Sent: 05 May 2010 11:53
To: Planning
Subject: Planning application S6/2010/298/FP - 45 Kentish Lane

Response to Planning application from Hertfordshire County Council (T and CP GDP Order 1995)

FORMATION OF NEW CROSSOVER AND DRIVEWAY AND ERECTION OF NEW BOUNDARY WALL AND G

SITE PLAN 1:500

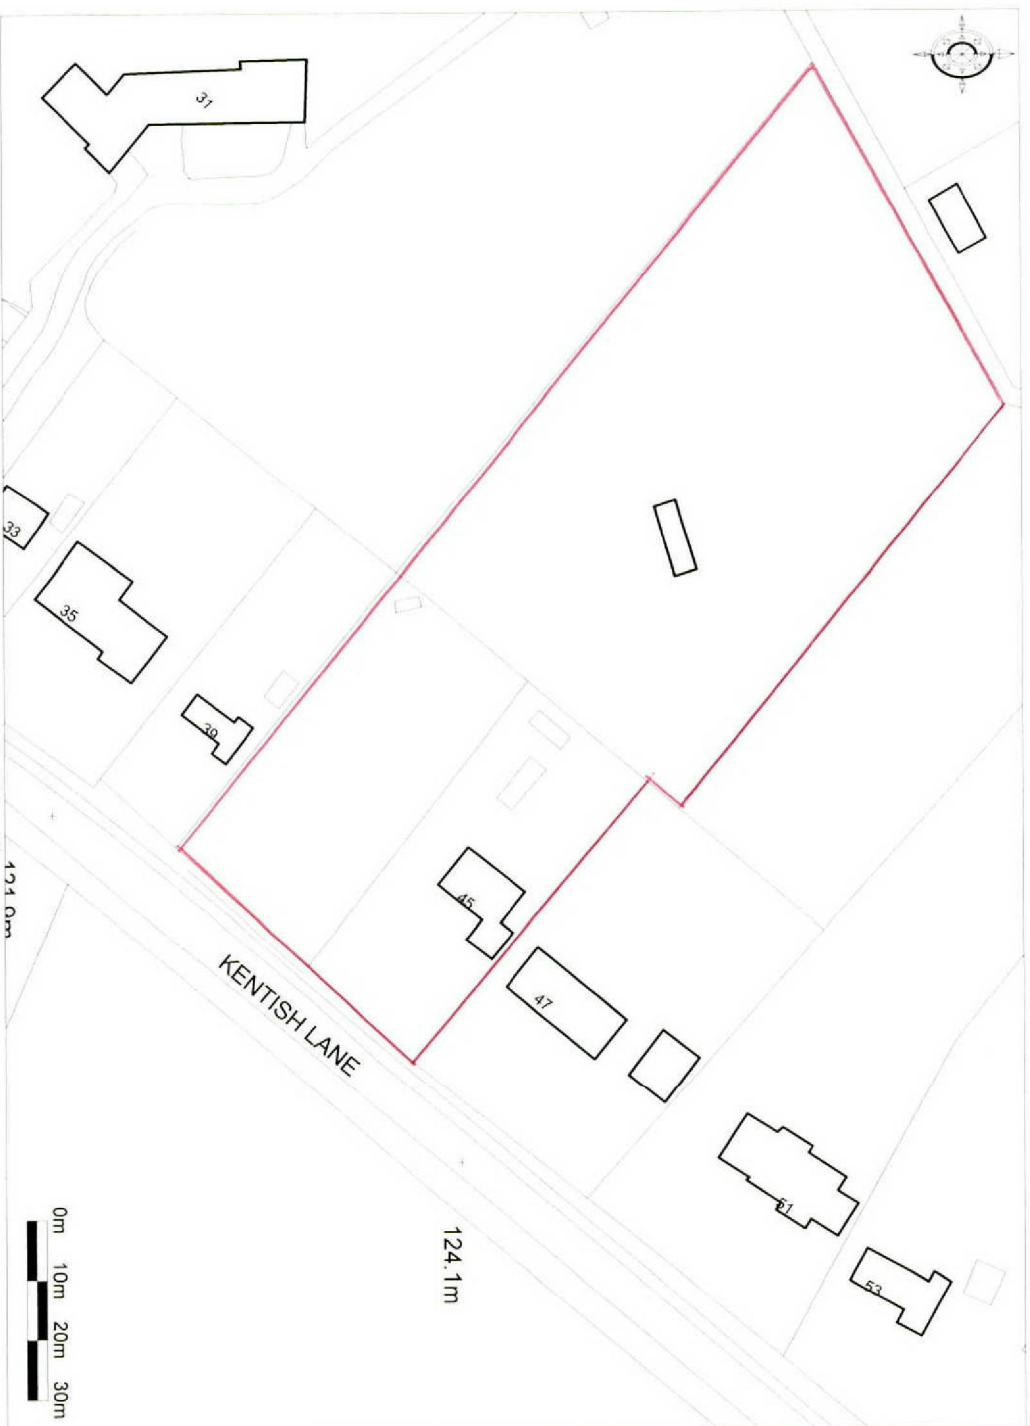
COMMENTS: This application is for the formation of new crossover and driveway and erection of new boundary wall and gates. However on visiting the site it appears that the dropped kerb for the new access is already there. One of the existing accesses is to be removed and the vehicle crossover for this access should be removed. The applicant should be advised to consult Herts Highways regarding this work. Kentish Lane is a classified road, the B158, and is designated as secondary distributor. The accesses have adequate visibility and the proposed layout will allow vehicles to enter and leave the site in a forward gear.

AN1. The highway authority requires the removal of the existing to be undertaken such that the works are carried out to their specification and by a contractor who is authorised to work in the public highway. The applicant will need to apply to the Mid West Hertfordshire Highways Area Office (Telephone 01727 816000) to arrange this.
